Response to Planning Application

Application ref: LU/152/20/RES

Description: Approval of reserved matters following LU/63/11 & LU/234/16/RES for construction of Fitzalan Link road between A259 Worthing Road & the East Street/Fitzalan Roundabout. This application affects a Public Right of Way. This application is not CIL Liable as other development (Zero Rated).

Summary recommendation: Recommend approval of the Landscape element to the proposals submitted under reserved matters application LU/152/20/RES

Drawing Title:
PROPOSED S38/S278 HIGHWAY WORKS
FITZALAN LINK
LANDSCAPE PROPOSALS 1 OF 2

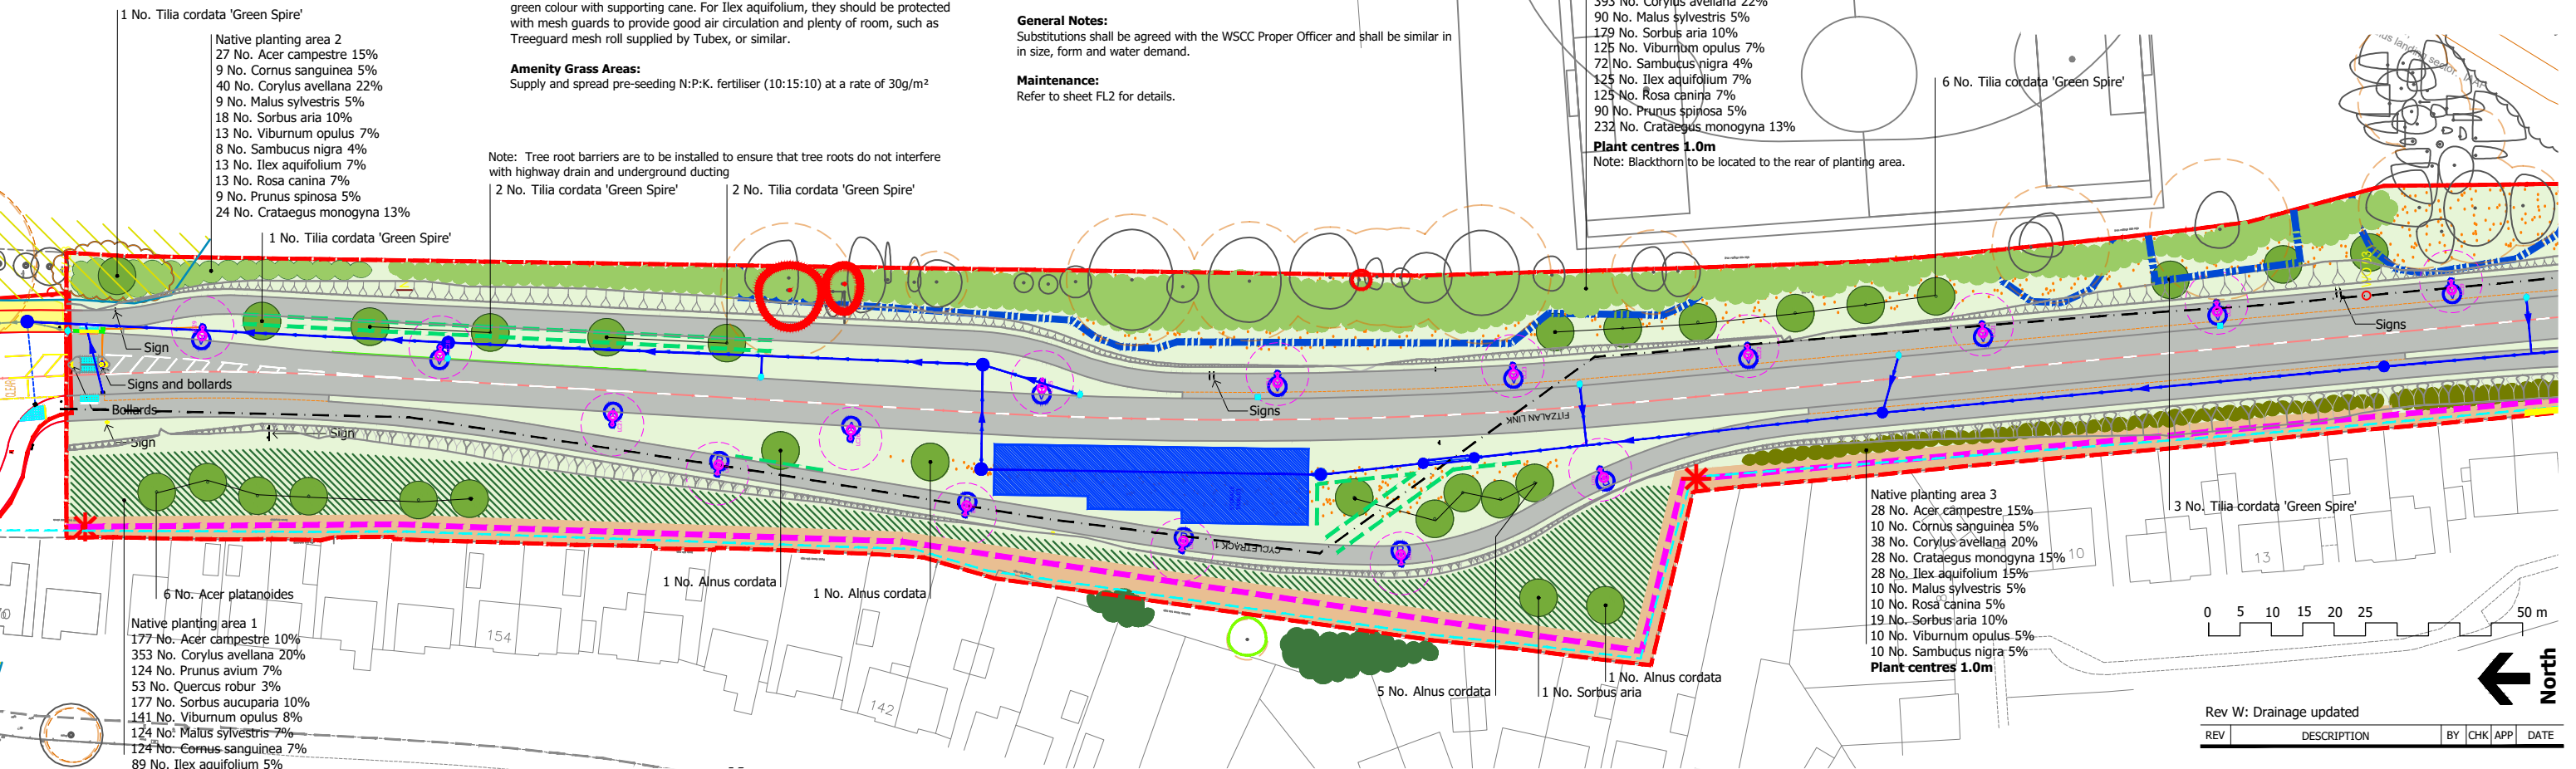
Further to submission of application LU/234/16/RES and the submission of revised plans under this application LU/152/20/RES Proposed S38/278 Highway Works Fitzalan Link Landscape Proposals DWGs 1 & 2 of 2 PHFL-WYG-S278-LP-FL1/2 Rev W A088461 FL1 & FL2 REV W, I can confirm that the amendments have considered our comments and have now included a scheme which does adequately address the lack of native planting and screening to the eastern and school boundary aspect of these proposals. The species choice and mix is suitable for location and purpose. The detail has now addressed the omission of planting numbers previously submitted re acoustic barrier and now reinstated these in line with the detail approved under LU/234/16/RES

The landscape scheme proposed under this reserved matters application in general provides a good species selection of mixed native evergreen and deciduous trees and shrubs, which if given the correct protection and aftercare would create a suitable scheme. The details show proposed planting including to the west of the proposals adjoining the existing housing, which when established with the existing retained vegetation will provide screening and buffer zone benefits in this area. The semi mature tree detail re species choice, sizes and location of planting is adequate for the location and over time will soften the proposals into the surrounding landscape providing a greening along this roadway. The tree species chosen will produce trees with a reasonably compact head form which has been considered in relation to spread, sight lines and street lighting.

Protection measures along with a comprehensive maintenance regime will need to be in place to ensure that the planting does establish, thrive and develop to the screen suggested. This would be particularly relevant to the semi mature trees being proposed which would form an important statement along these proposals. The future long term maintenance should also be considered post establishment regarding the tree protection methods initially employed, these will require a strategy in place for their ultimate removal once no longer required and before they become a litter issue and hazard.
